Submissions Report
New High School in Jerrabomberra
SSD-24461956

On behalf of
NSW Department of Education
March 2022

This Submissions Report has been prepared by Mecone NSW Pty Limited on behalf of the NSW Department of Education to support the proposed new high school in Jerrabomberra (SSD-24461956).

ACCESSIBILITY VIA DAVID MADEW OVAL

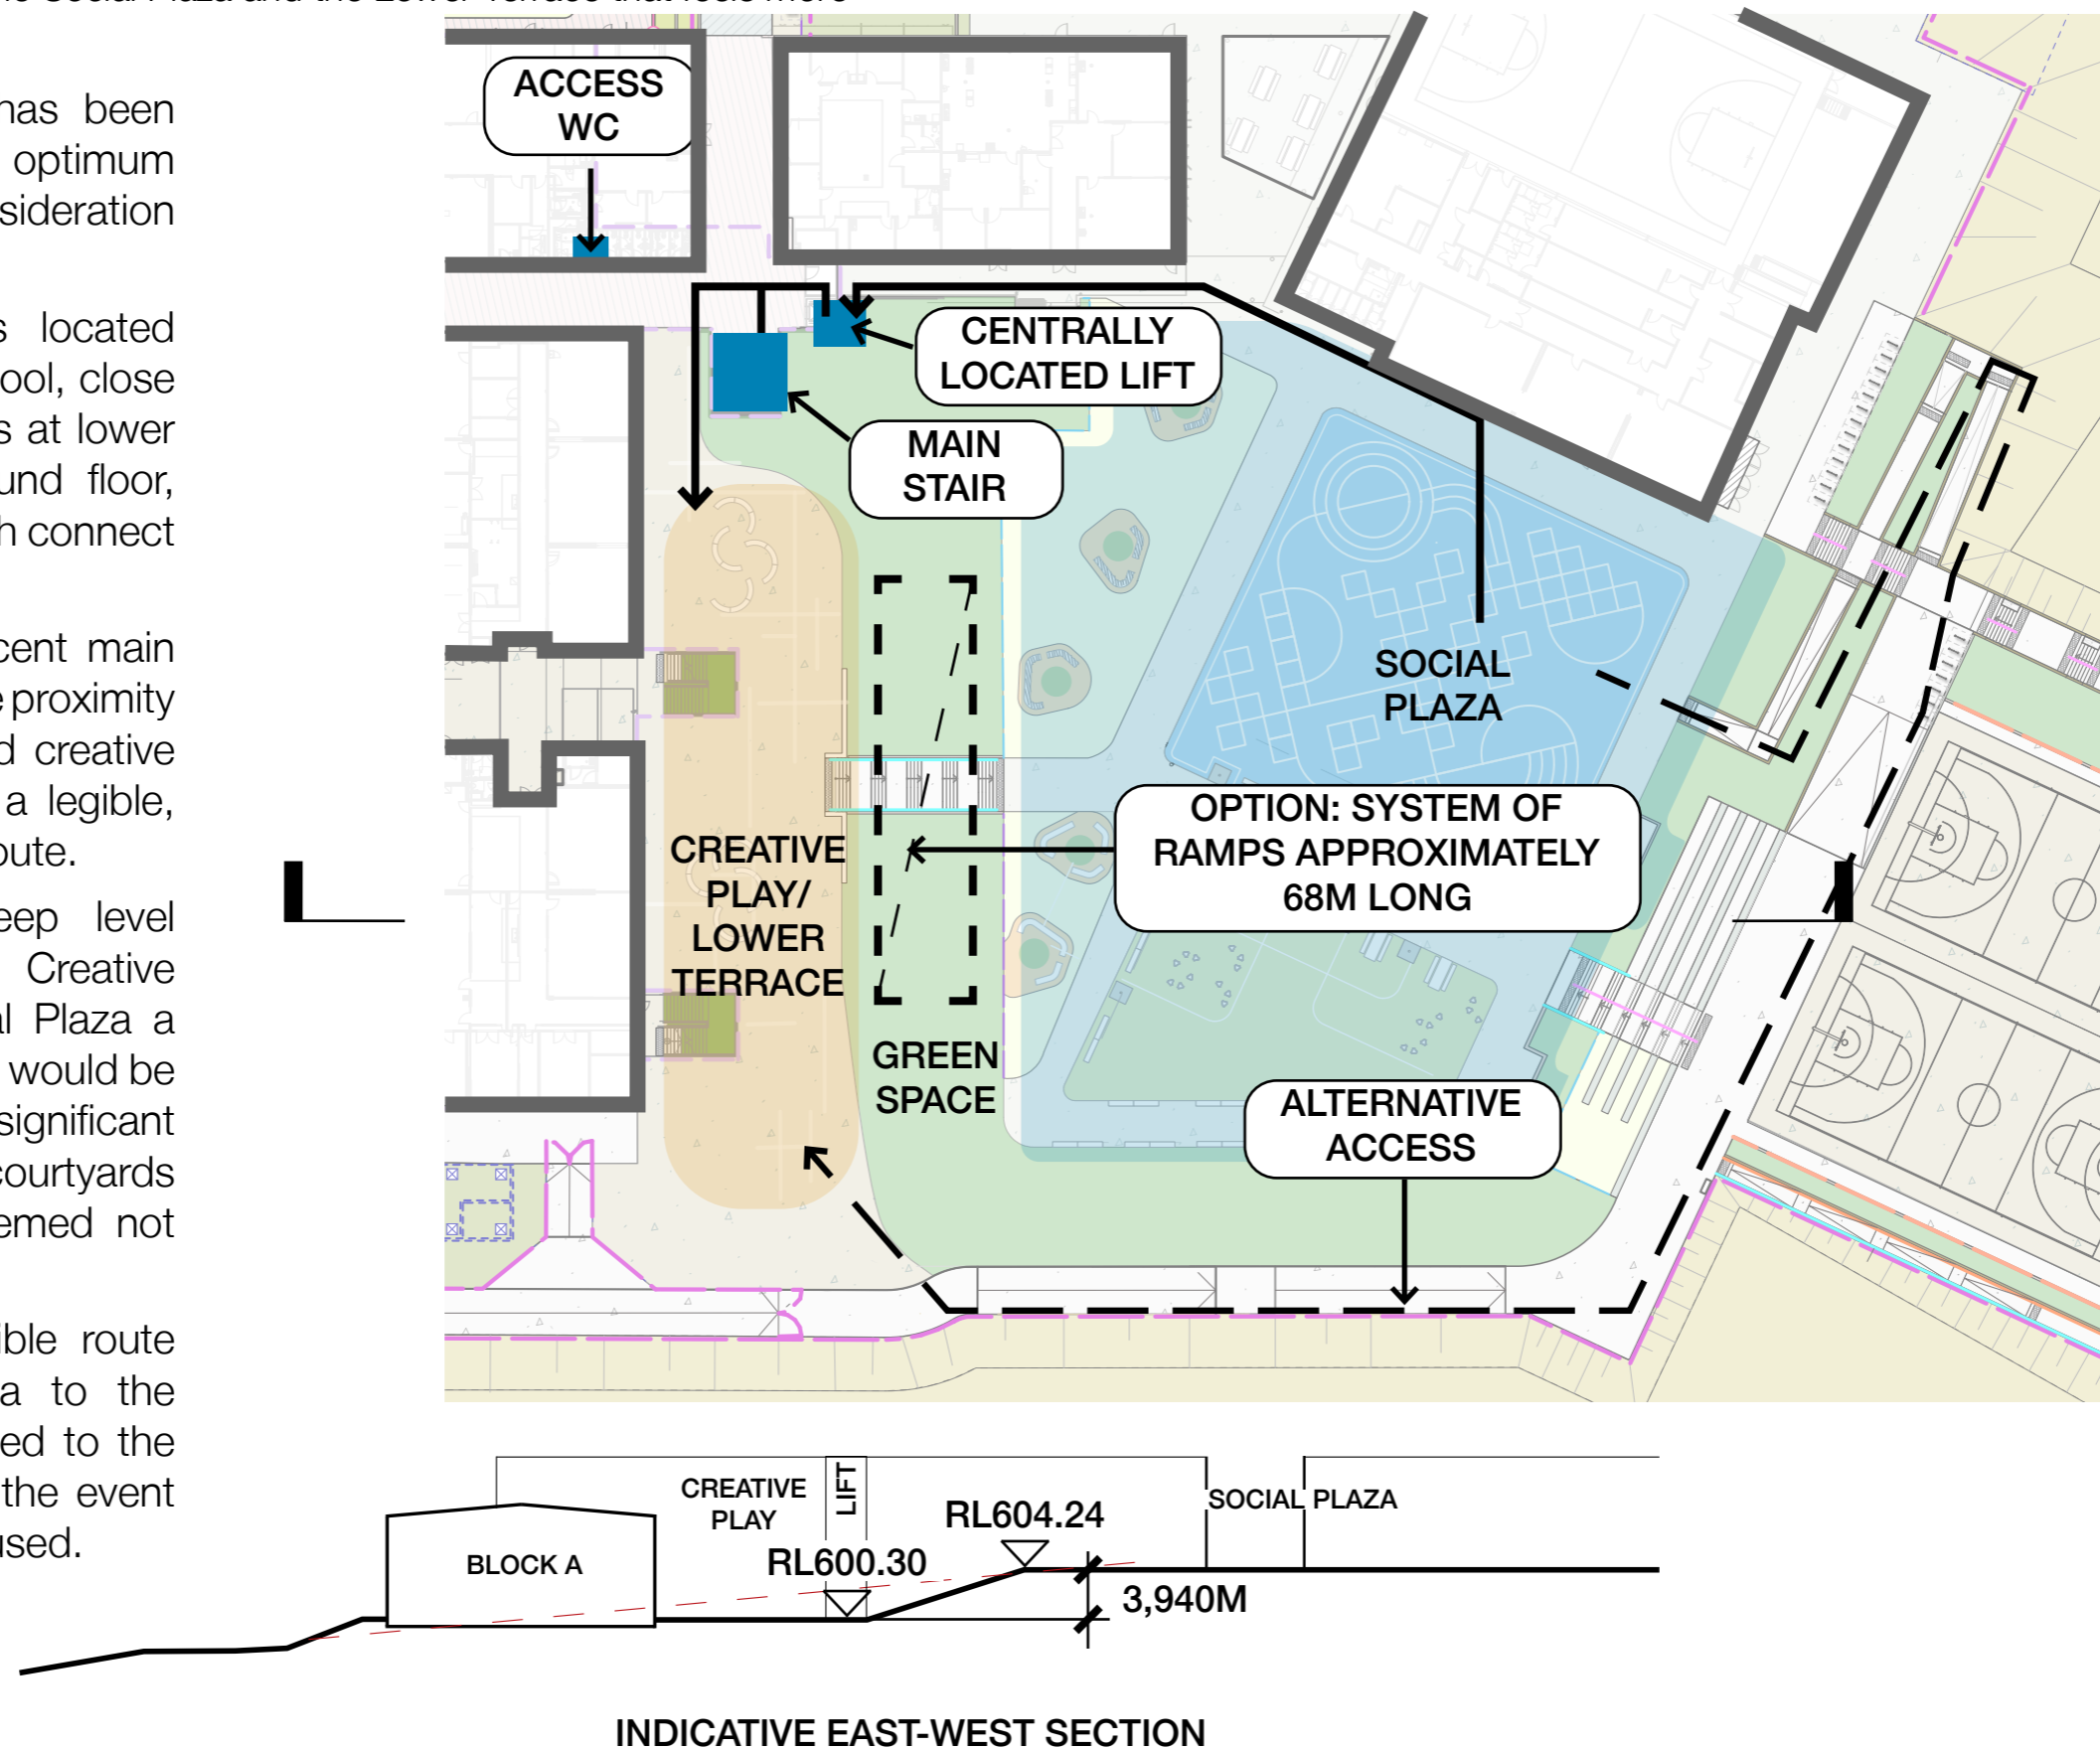
Key issue	Response
2. Design and Built Form	
<p>The Government Architect NSW has advised that the proposal has not adequately addressed a number of matters raised in the State Design Review Panel (SDRP) advice dated 15 July 2021.</p> <p>The following recommendations of the SDRP advice must be addressed:</p> <ul style="list-style-type: none"> • Recommendation 7c – the response does not include any options testing, and the recommendation to explore how the connection between the David Madew Oval and the school is connected and inclusive has not been adequately addressed. Options to provide an inclusive and equitable connection between the Oval and the school must be explored. 	<p>The connection to the David Madew Oval has been addressed within the constraints presented by the topography of the site. A series of ramps compliant with the enhanced requirements of AS 1428.2-1992 have been provided adjacent to the steps, ensuring that all users have choice to address the level change in the way most appropriate to their needs or disability. The ramps meet the EFSG requirement to provide landings at 6m intervals (in lieu of 9m intervals as per the requirements of the BCA) to ensure the route is suitable for students or users who might tire more easily. Rest points with seating are incorporated at a maximum of 50m intervals along the ramped route, to allow an opportunity for students and staff to rest and recover, extending the ability to comfortably travel longer distances. Refer to TKD's response at Appendix 7 for further discussion.</p>

<p>The school campus has been designed to allow for optimum accessibility with consideration of the site contours.</p> <p>The lift and adjacent main stair, which are centrally located and connect all levels of the school, are located in close proximity to the social plaza and creative play space, providing a legible, pragmatic circulation route.</p> <p>To transition the steep level change between the Creative Play space and Social Plaza would require a large network of ramps, removing a significant portion of the central courtyards green space. This option, therefore, was deemed detrimental to the quality of the external space.</p> <p>An alternative accessible route from the Social Plaza to the Creative Play is provided to the south of the plaza in the event the lift is unable to be used.</p>
<ul style="list-style-type: none"> • Recommendations 11 and 12a – opportunities must be pursued to articulate the volume of Building A along Environa Drive to reduce the visual bulk and allow for more opportunities for natural ventilation. 	<p>Building A has been further articulated to reduce visual bulk and allow for more natural ventilation. This has been achieved through breaks in the building form and revisions to the fenestration. Refer to TKD's response at Appendix 7 for further detail and also the description in Table 1.</p>
